Suffolk County Council (20050784)

Comments on submissions received at
Deadline 5

North Falls (EN010119)

24 June 2025

# **Onshore Substation Zone of Theoretical Visibility and Viewpoint Locations with Dedham Vale National Landscape**

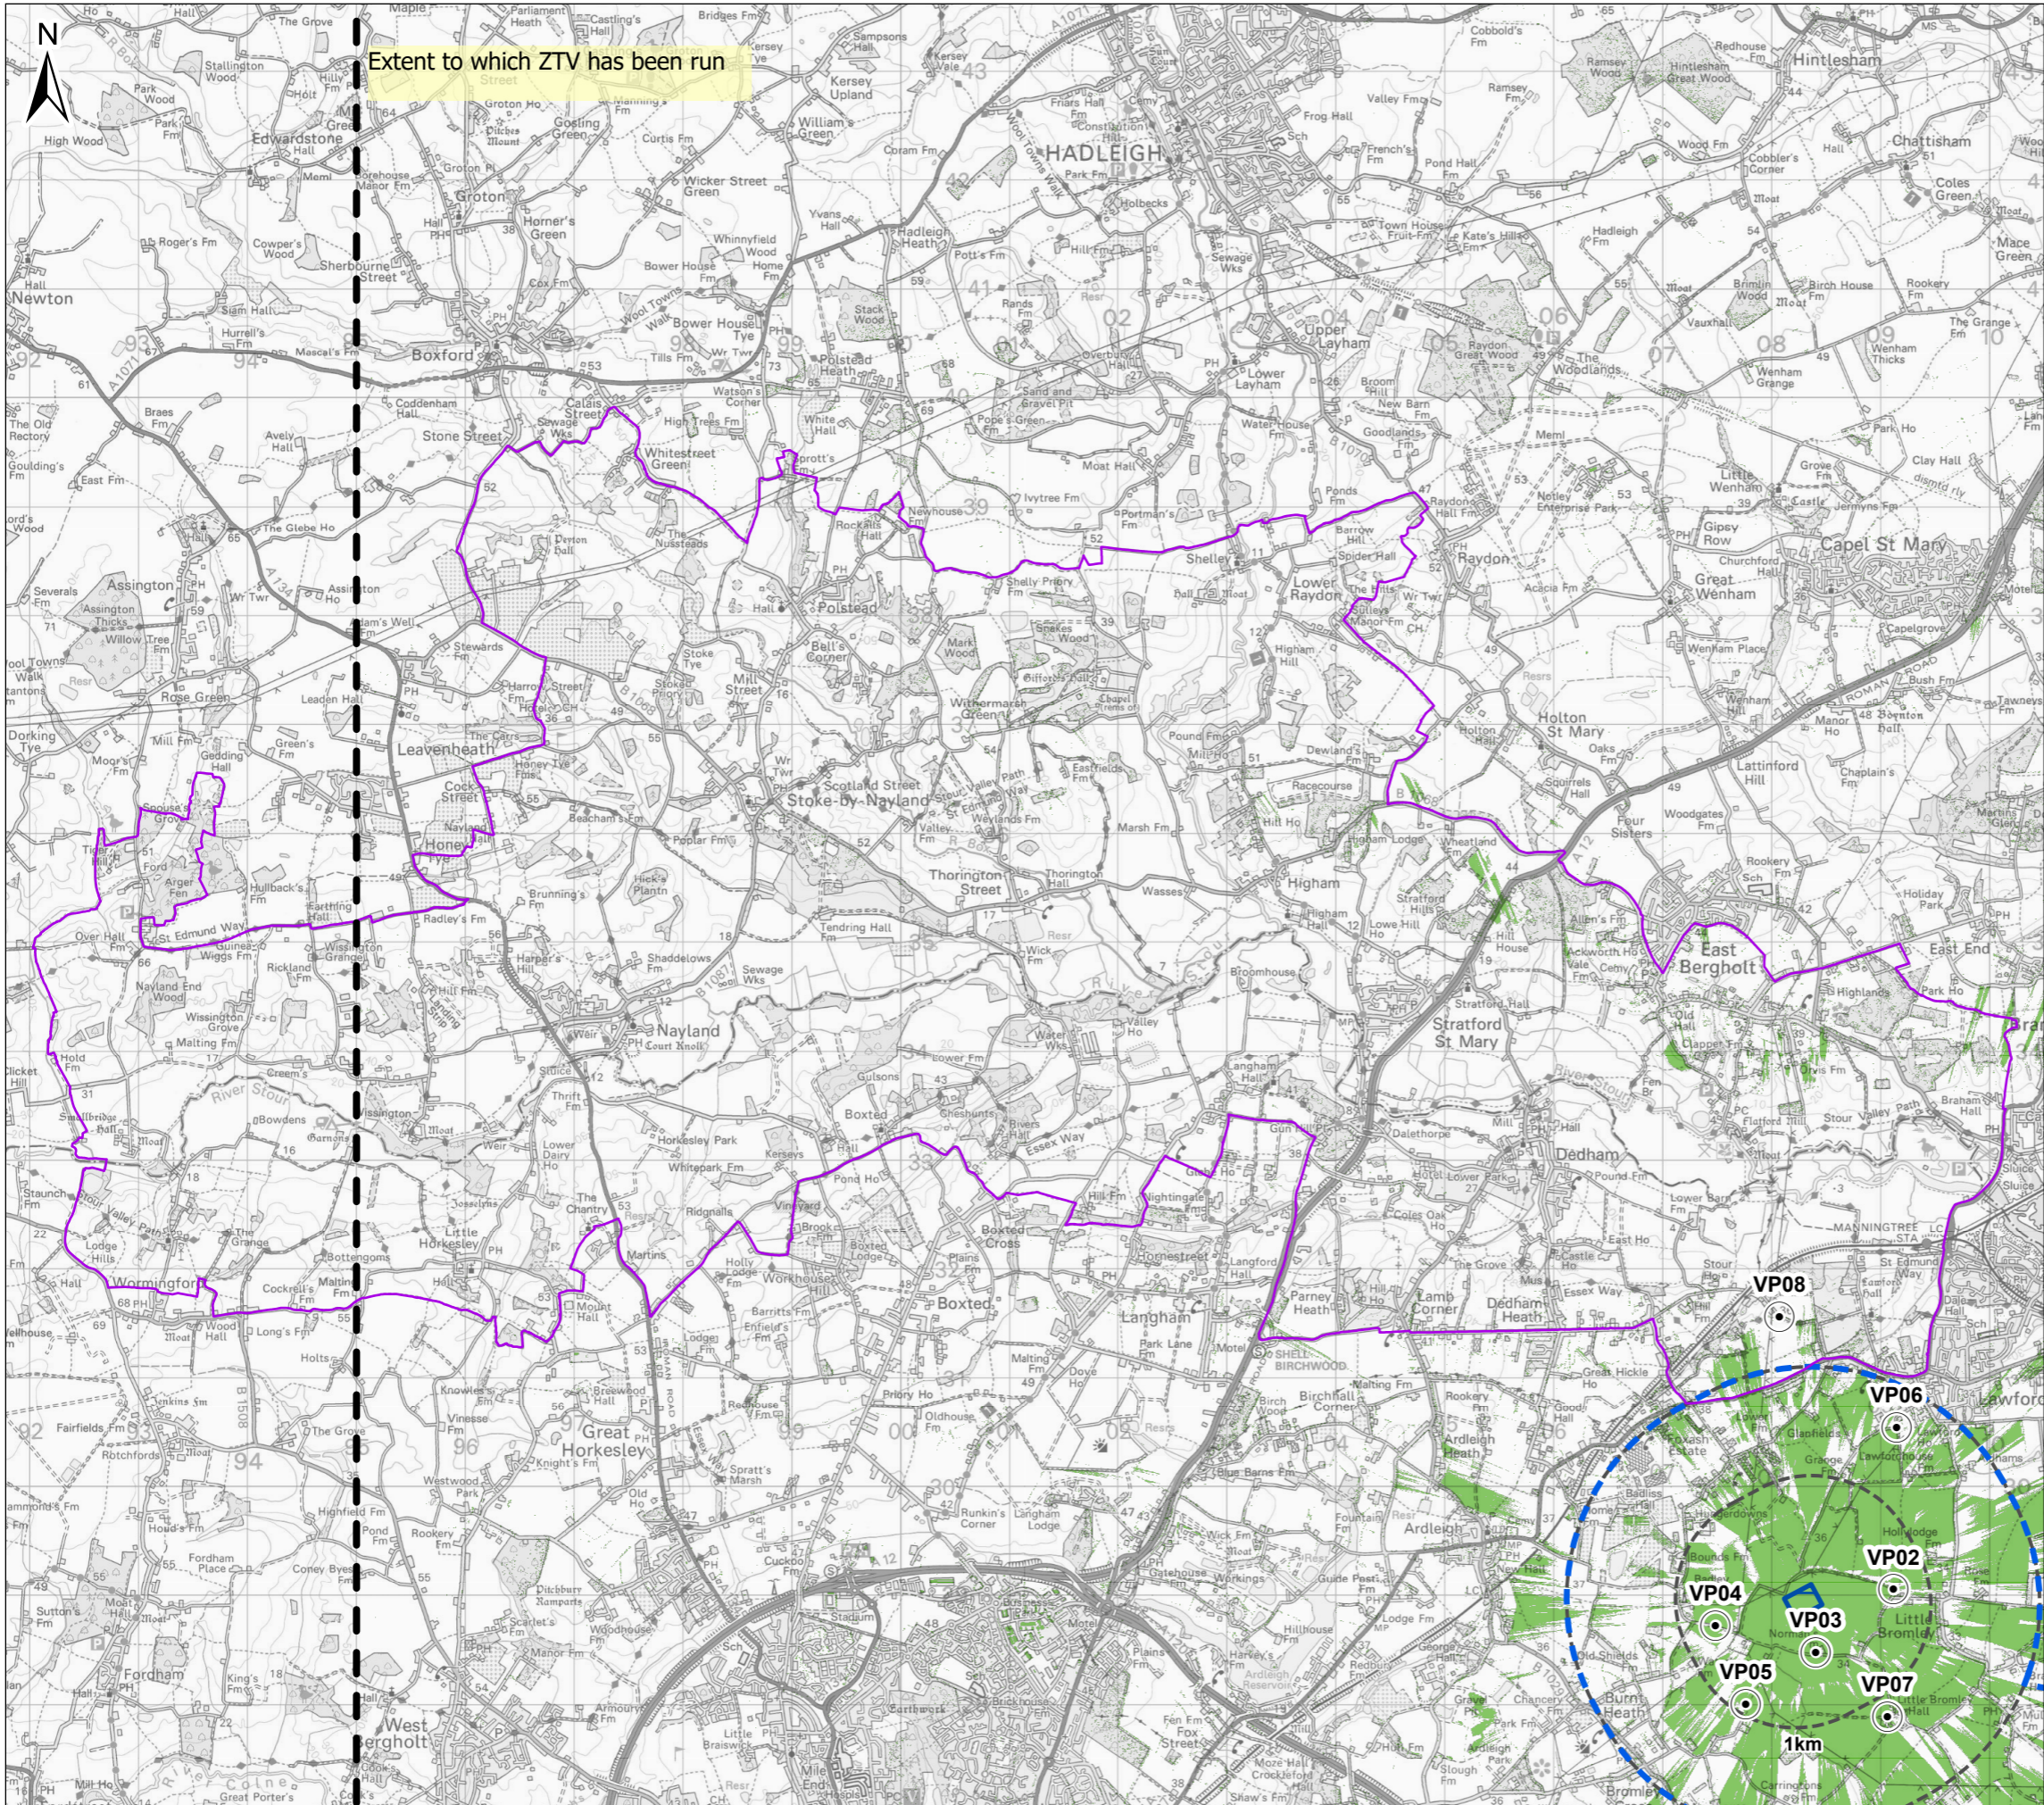
| Table 1: SCC Table of Comments on 9.78 Position Statement on various issues relating to National Landscapes (Rev 0) [REP5-068] | | | | |
|--|-----------------------------|------------------|---|---|
| 1a | Compliance with Duty (DVNL) | 1 | <p>SCC refers the Applicant to [REP5-116] where SCC recommends the inclusion of viewpoint assessments from areas which indicate greater visibility of the substation from the DVNL within the 2km study area. This point has been made in representations from previous deadlines including [REP1-074], [REP2-059] and [REP4-094]. For it to be determined whether the DVNL is affected, and whether any measures undertaken in accordance with the duty to be considered reasonable, proportionate, appropriate and sufficient, the extent of the impacts on the DVNL must be assessed.</p> <p>As a matter of clarification, SCC would like to make the point that it is not saying that simple visibility of the development from within the DVAONB is necessarily an adverse effect (i.e. mere intervisibility is not necessarily to be regarded as harmful) and that what matters is the nature and extent of any visual impacts, which is a matter for assessment and professional judgment. SCC notes that at ISH1 the Applicant drew a distinction between visibility and visual impacts (as set out in its Post Hearing Submissions in [REP4-026], item 3.1). Where the visual effects are assessed, even after any proposed mitigation such as landscape planting/screening, to result in some detrimental effects on the special qualities or natural beauty indicators of the DVAONB then those effects will be a residual adverse effect on the DVAONB and there will be a failure to</p> | <p>[REP1-074]</p> <p>[REP2-059]</p> <p>[REP4-026]</p> <p>[REP4-094]</p> <p>[REP4-096]</p> <p>[REP5-116]</p> |

| 1j | Application of the Duty | 14 | SCC has stated in previous submissions (such as [REP5-116]) that there remain unassessed zones of theoretical visibility in the DVNL within the 2km study area which suggest greater visibility than the assessed viewpoint from within the DVNL. SCC therefore queries how the Applicant is confident that there will be no impact on the DVNL resulting from the proposed development. | [REP5-116] |
